RE: Response Letter to the CSU Review Comments dated February 20, 2020 – O'Reilly Auto Parts, Colorado Springs, CO.

Please find below the responses to the CSU Review Comments for the proposed O'Reilly Auto Parts in Colorado Springs, CO.

COLORADO SPRINGS UTILITIES

**1 SITE UTILITY PLAN**  
C3.1 SCALE: 1" = 20'-0"

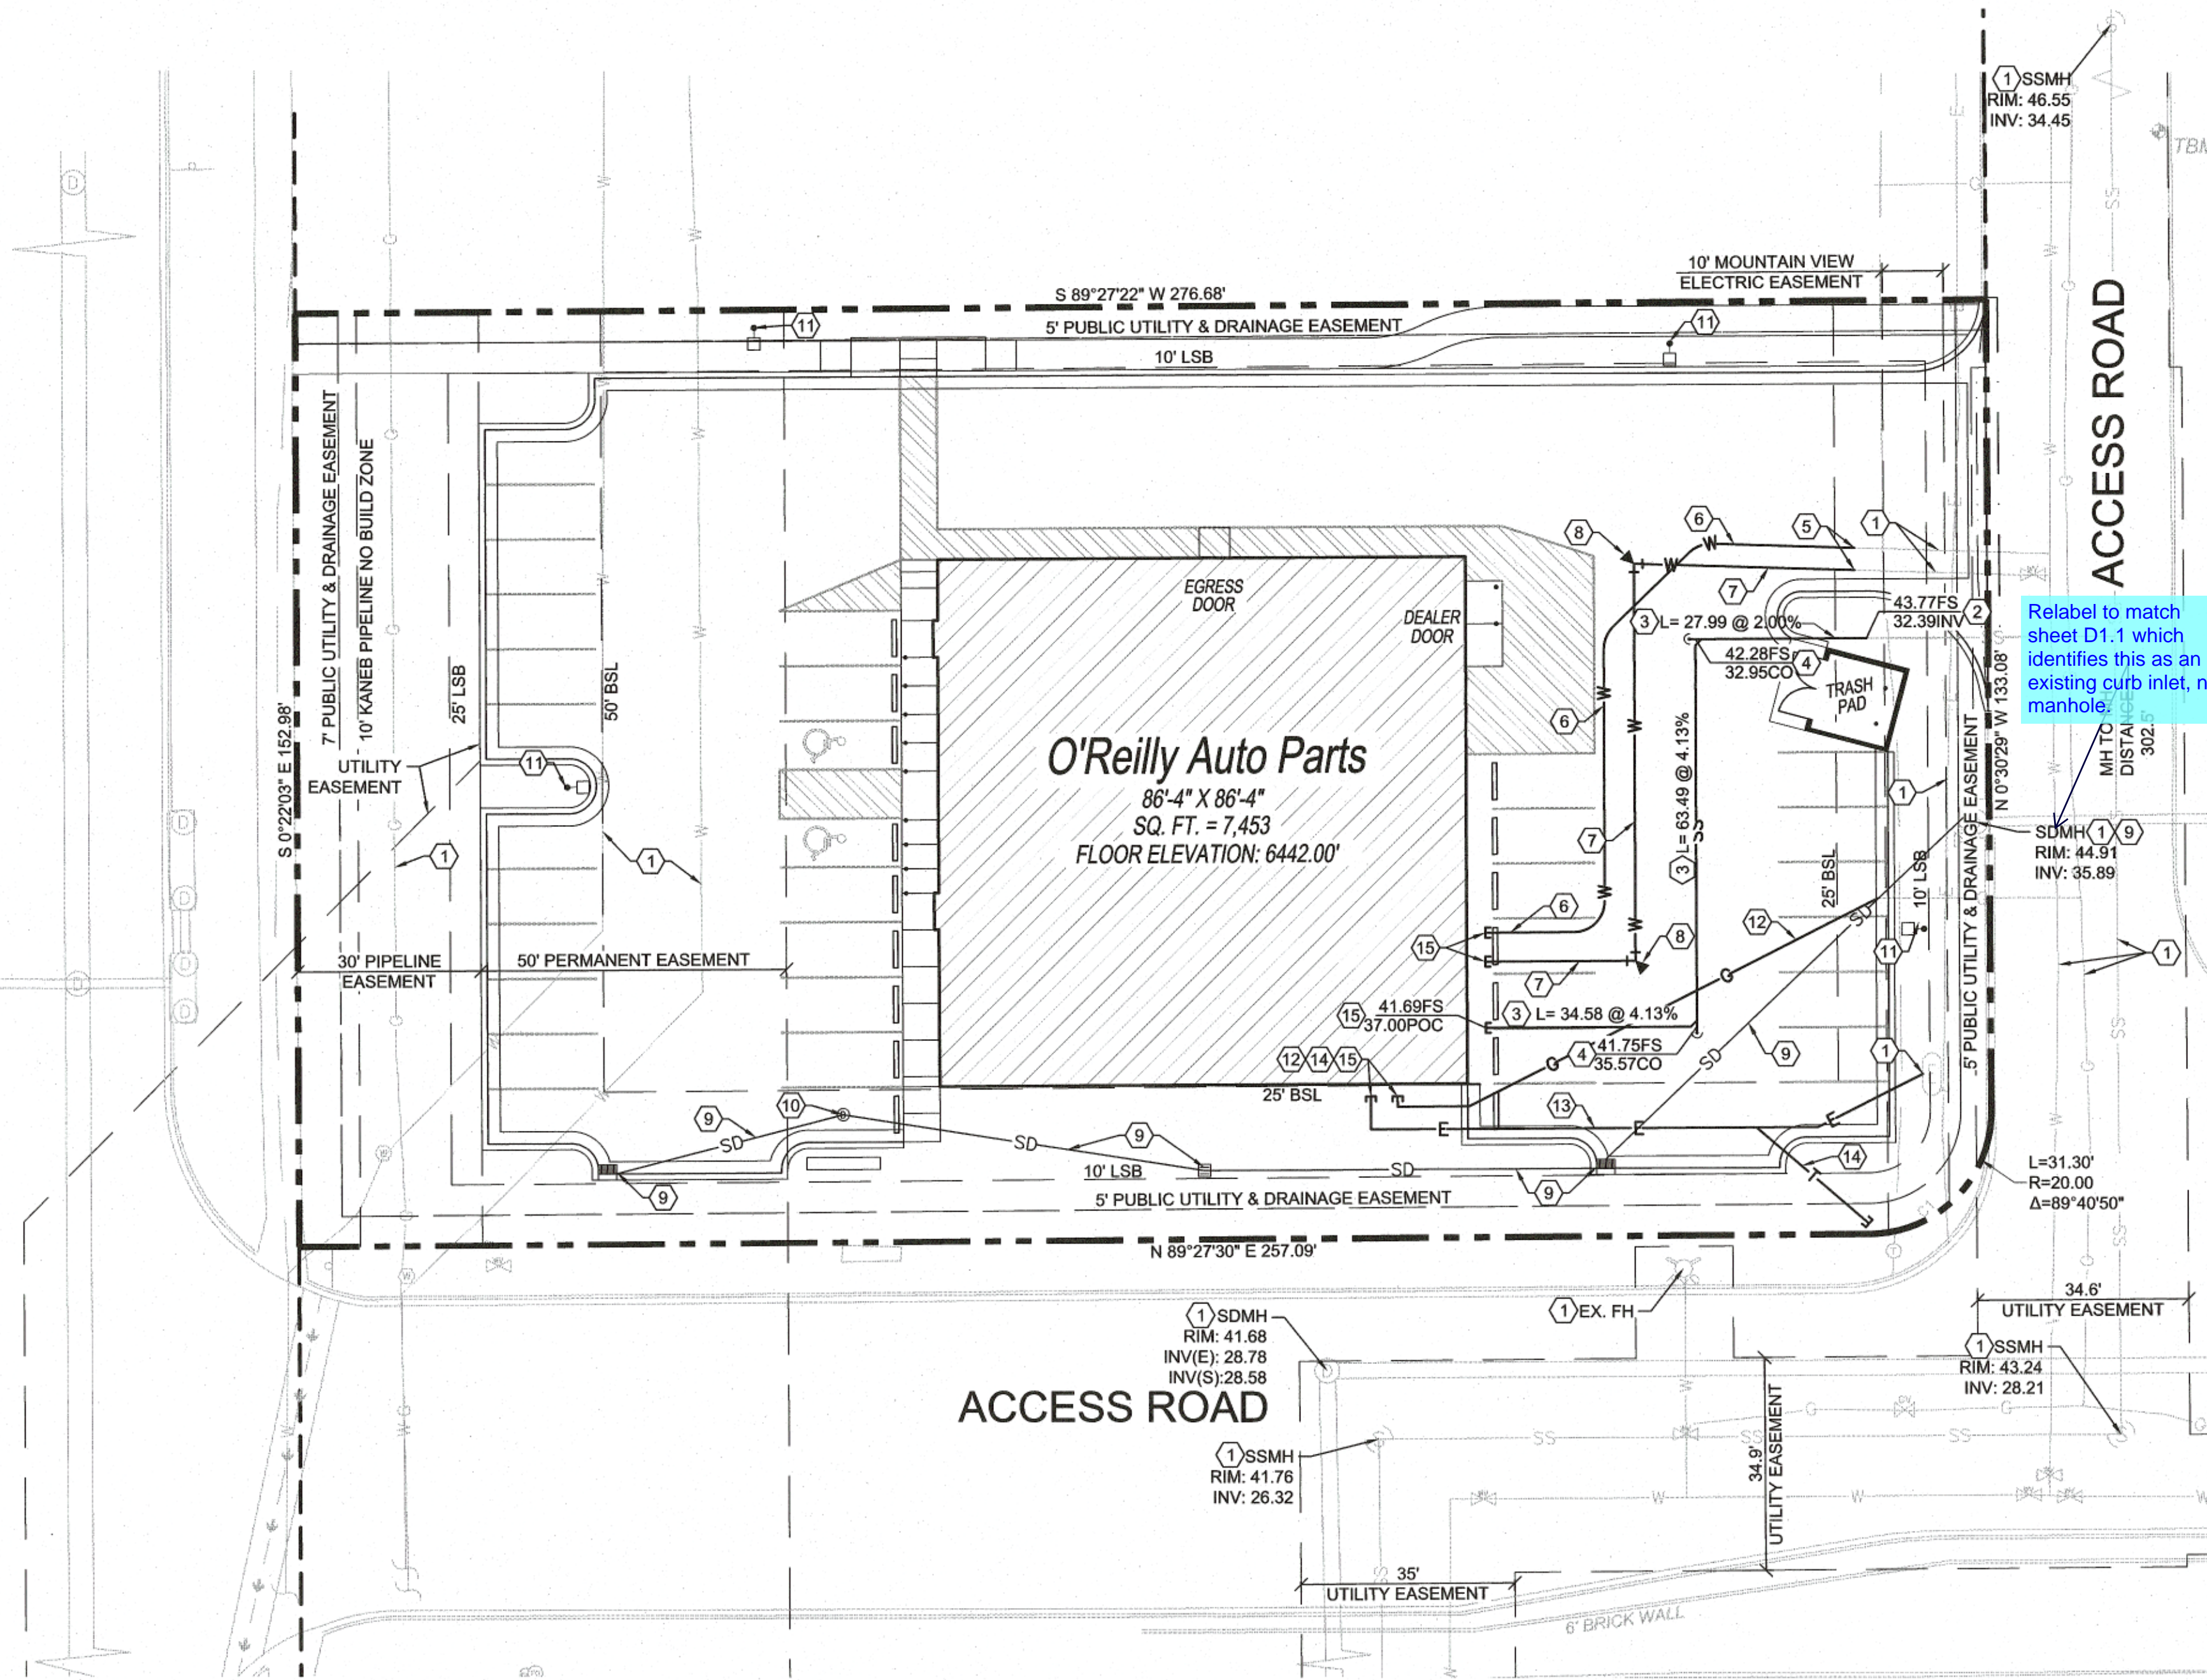
1. Please label reception numbers for existing easement.
Response: The reception numbers for the existing easement has been labeled on Sheet C3.1 Site Utility Plan.
2. Please show and label size, material, and public for the existing water mains on the site development sheet.
Response: The size, material, and public label have been added to the existing water mains on the Site Development Plan and the Site Utility Plan.
